Application Ref:	2025/0745			 Ribble Valley Borough Council <small>www.ribblevalley.gov.uk</small>
Date Inspected:	3.10.25	Site Notice:	3.10.25	
Officer:	Stephen Kilmartin			
DELEGATED ITEM FILE REPORT:				APPROVAL

Development Description:	Listed Building Consent for reinstatement of window and greenhouse in garden.
Site Address/Location:	Duke of York Inn Grindleton Brow Grindleton BB7 4QR

Proposed Glass House

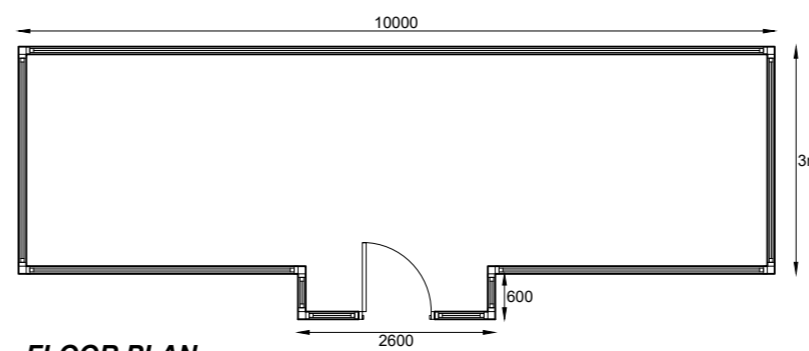
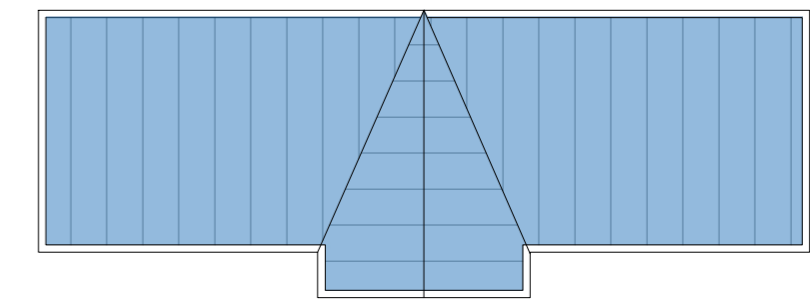
It is proposed that the greenhouse structure will be located at the north-eastern extents of the 'garden' area of the property, being built off the existing shared boundary stone wall to the rear of numbers 2 and 3 Kayley Terrace. The greenhouse will benefit from a footprint of 10m by 3m with a small central gable projection projecting 600mm westward from the primary elevation of the structure. The structures will measure 2.9m at its highest point with an eaves height of approximately 2.1m, with the highest part of the structure being approximately 600mm lower than the highest point of the boundary wall that it will benefit from a direct interface with.

The structure will be of a mono-pitch configuration with the elevations and roof being predominantly glazed, save that from a natural stone lower perimeter wall element upon which the glazed structure will be constructed. It is proposed that the greenhouse glazed element will be of a timber frame construction.

In respect of the design and configuration of the greenhouse, the proposed elevational language, materials and glazing arrangement is considered to be sympathetic to the character of the existing building and by virtue of its distance from the Grade II Designated Heritage Asset, is unlikely to result in any significant measurable harm to the inherent character or significance of the asset.

In respect of potential impacts upon existing residential amenities, given that the structure is to be set approximately 600mm lower than that of the shared boundary stone wall to the rear of numbers 2 and 3 Kayley Terrace, it is not considered that the structure will result in any adverse impacts by virtue of overbearing impact nor loss of light.

Furthermore, taking account of the relationship of the structure with the shared boundary wall and the orientation of the glazed elements of the greenhouse, it is not considered that the proposal will result in any adverse impacts upon the residential amenities of amenities of nearby residential occupiers by virtue of a loss of privacy.
